May 17, 2024

Re: 543 Old Coors/ BUILDING B
543 Old Coors Dr. SW
30-Day Temporary Certificate of Occupancy
Transportation Development Final Inspection
Architect's Stamp dated 10-22-22 (K11-D027)
Certification dated 05-16-24

Based upon the information provided in your submittal received 05-16-24, Transportation Development has no objection to a 30-day Temporary Certificate of Occupancy based. This letter serves as a "green tag" from Transportation Development for a 30-day Temporary Certificate of Occupancy to be issued by the Building and Safety Division.

SITE PLAN

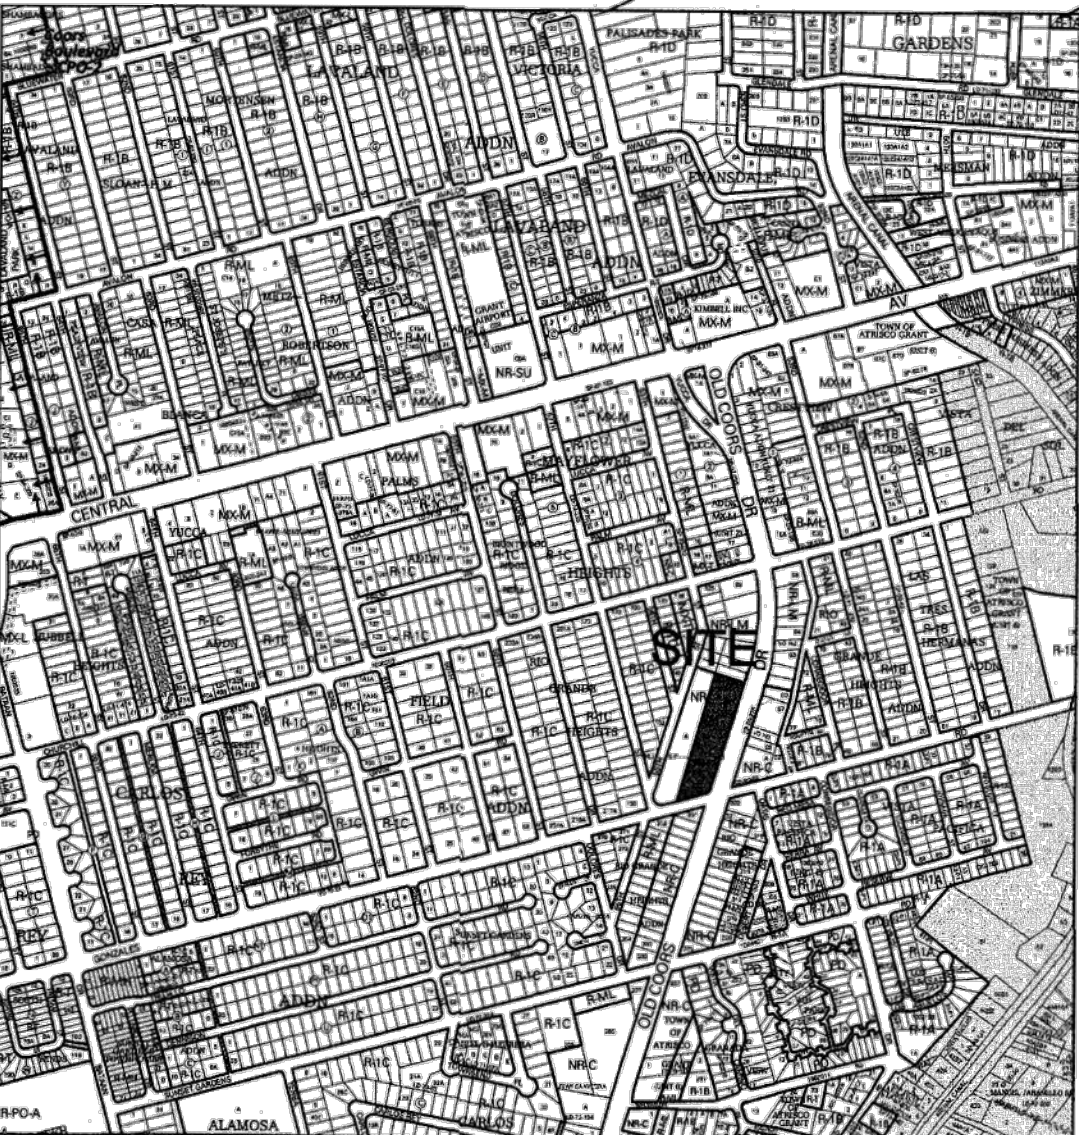
1. Per approved plan keynote 37: Truncated Domes must be installed at the corner of Old Coors Dr. and Gonzales Rd.

2. Please provide Motorcycle parking sign posted upright sign, either free-standing or wall mounted per the zoning code.
3. Per site visit new parking spaces have been provided on south side of the site. Please red mark the site plan to reflect this changes.
